Comment for planning application 23/00977/OUT

Application Number	23/00977/OUT
Location	OS Parcel 9195 North Of Claydon Road Cropredy
Proposal	Outline Planning Application (except for access) for residential development of up to 60 dwellings (Use Class C3) including a community facility, new vehicular and pedestrian access off Claydon Road, public open space and associated landscaping, earthworks, parking, engineering works and infrastructure
Case Officer	Katherine Daniels
Organisation	
Name	Gareth Denton
Address	Reads House, Creampot Lane, Cropredy, Banbury, OX17 1NT
Type of Comment	Objection
Type	neighbour
Comments

Further objections from Neighbour (Reads house, Creampot lane, Cropredy).

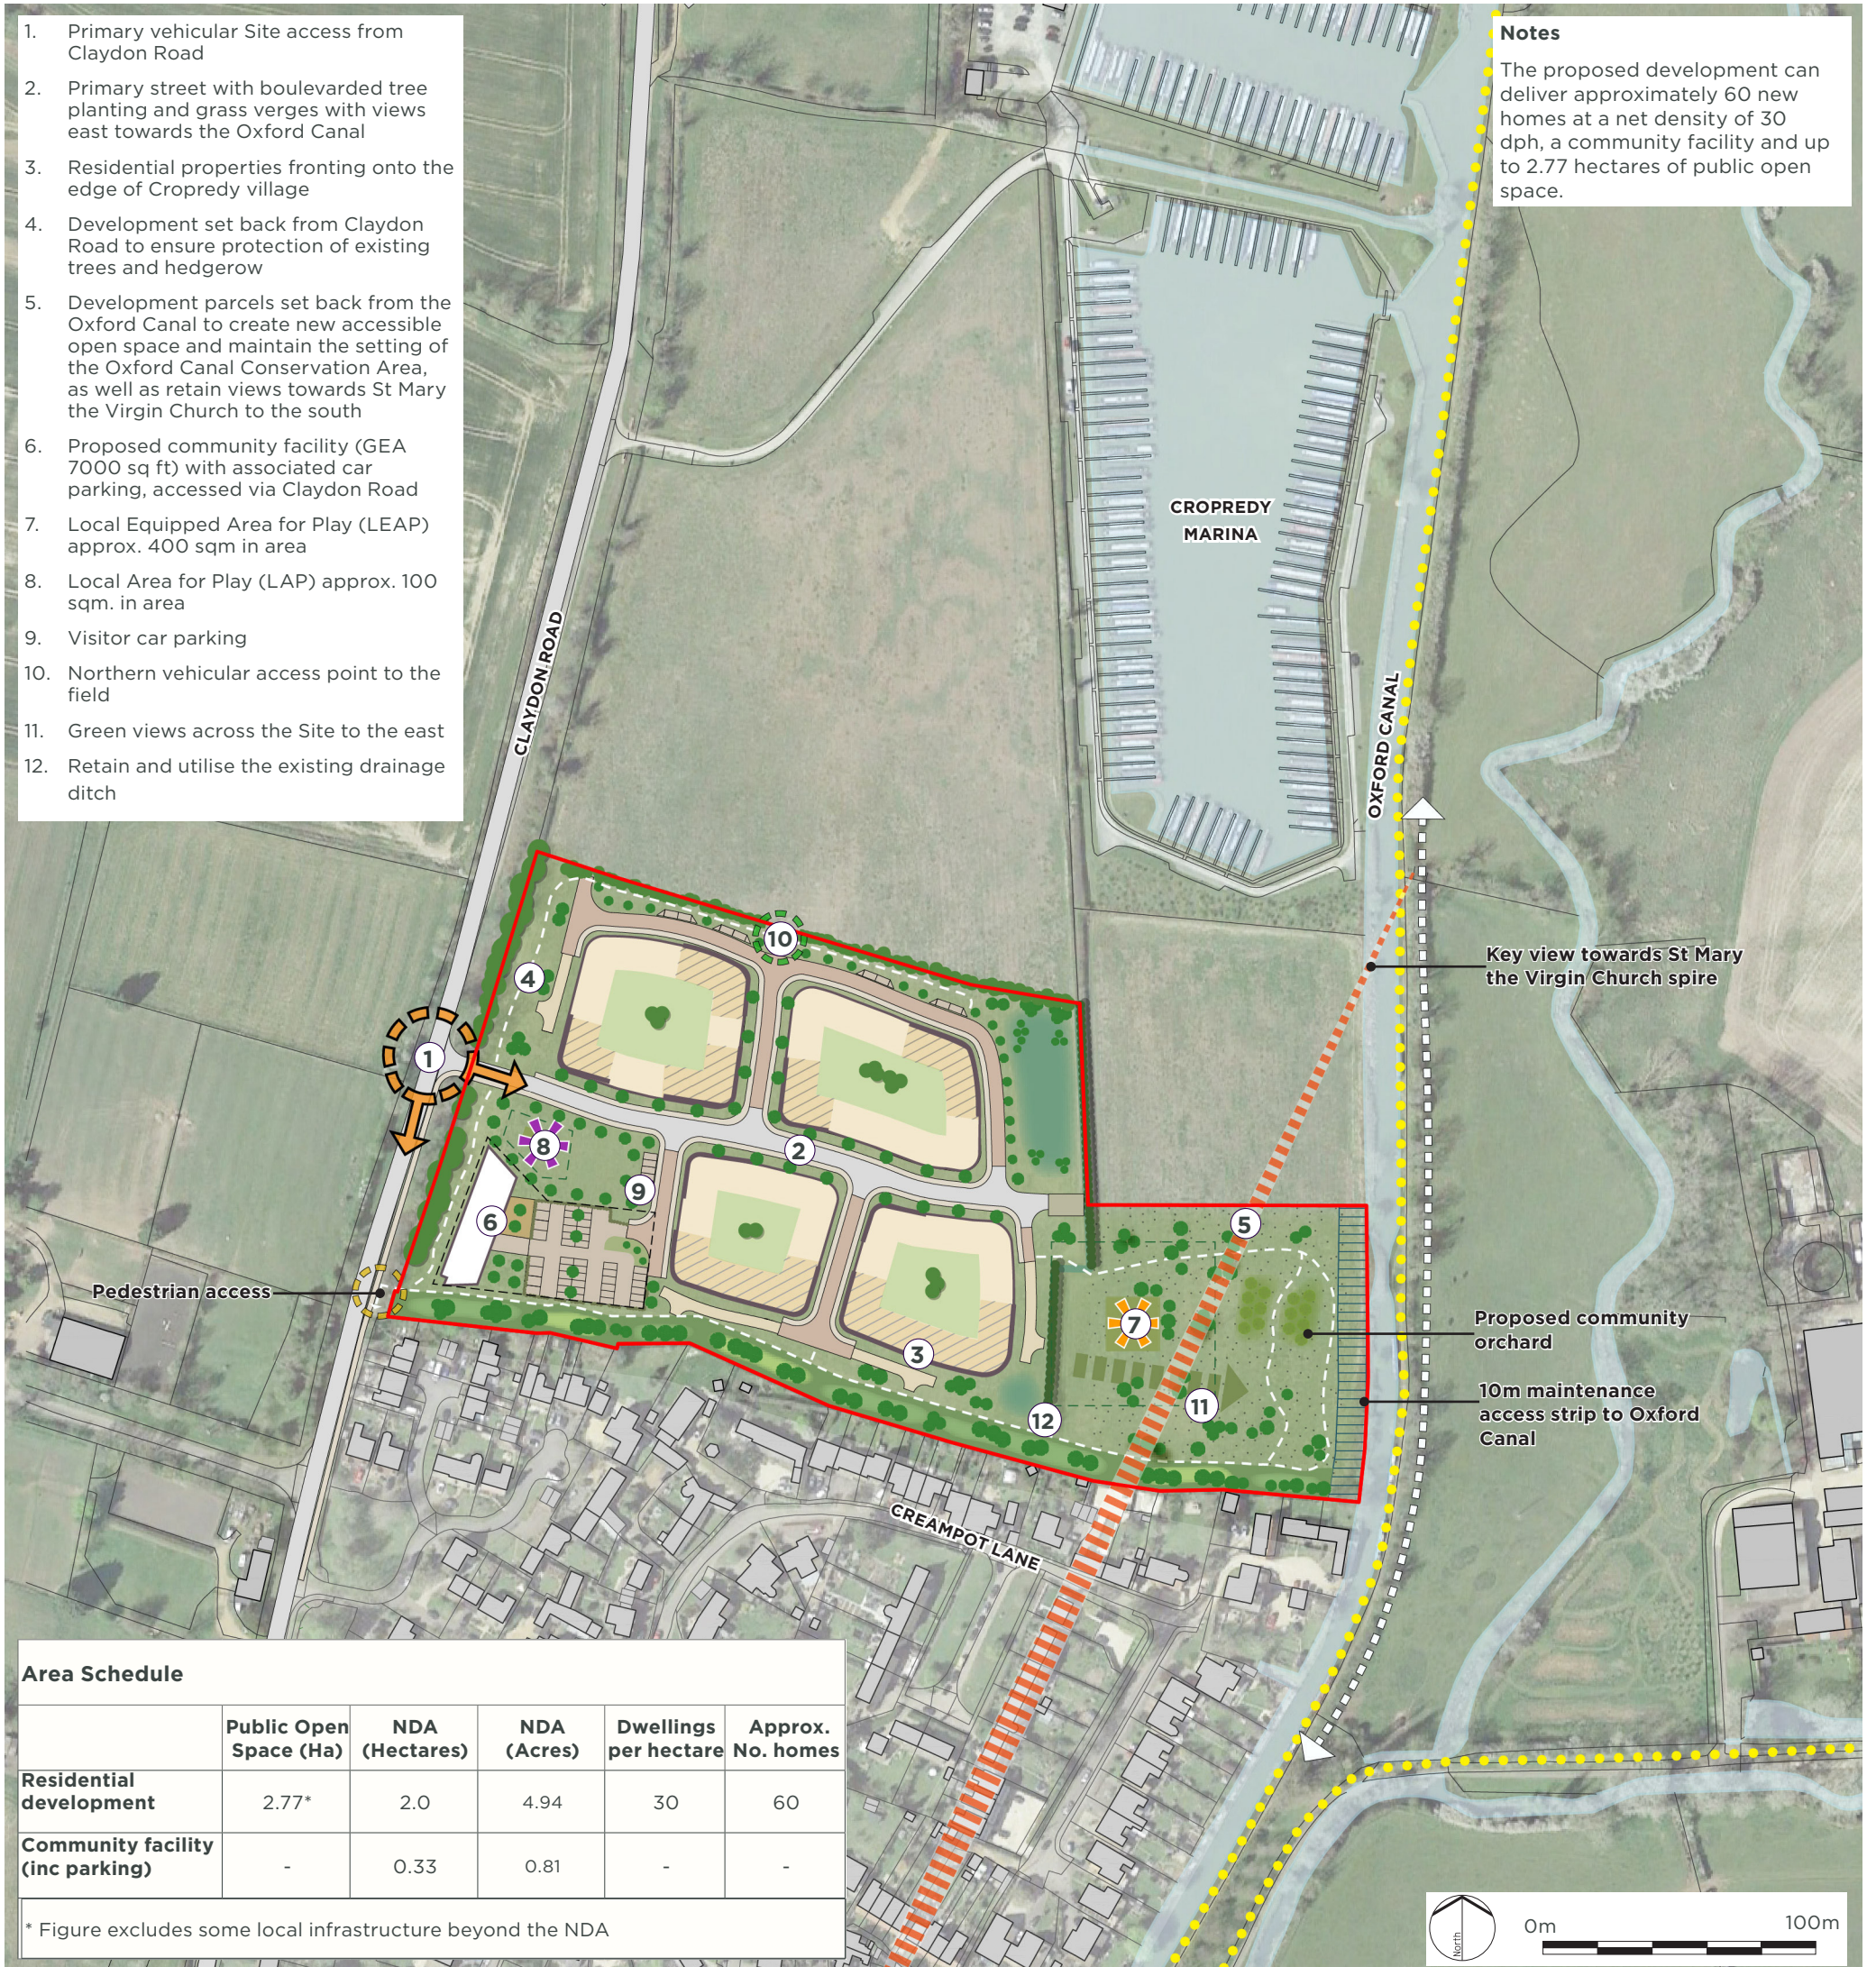
1. The plans for this planning application have a small SuDS located at the south end of the development by the existing hedge line. This has been placed at the highest point in the local topography of the field and baffles me to know how Obsidian expect water to flow uphill.

2. The field is located within a clay basin and Obsidian have stated that the main SuDS will not drain naturally (and plan to discharge it into the canal). If the main SuDS will not drain naturally, then the only drainage method for the smaller SuDS will be to let it deliberately overflow (assuming it fills in the first place) and overspill into the neighbouring gardens of the existing residents properties.

5. The wide boarder to the southern boundary on the plan seems to be a method of not having to deal with the runoff from the field rather than addressing it.
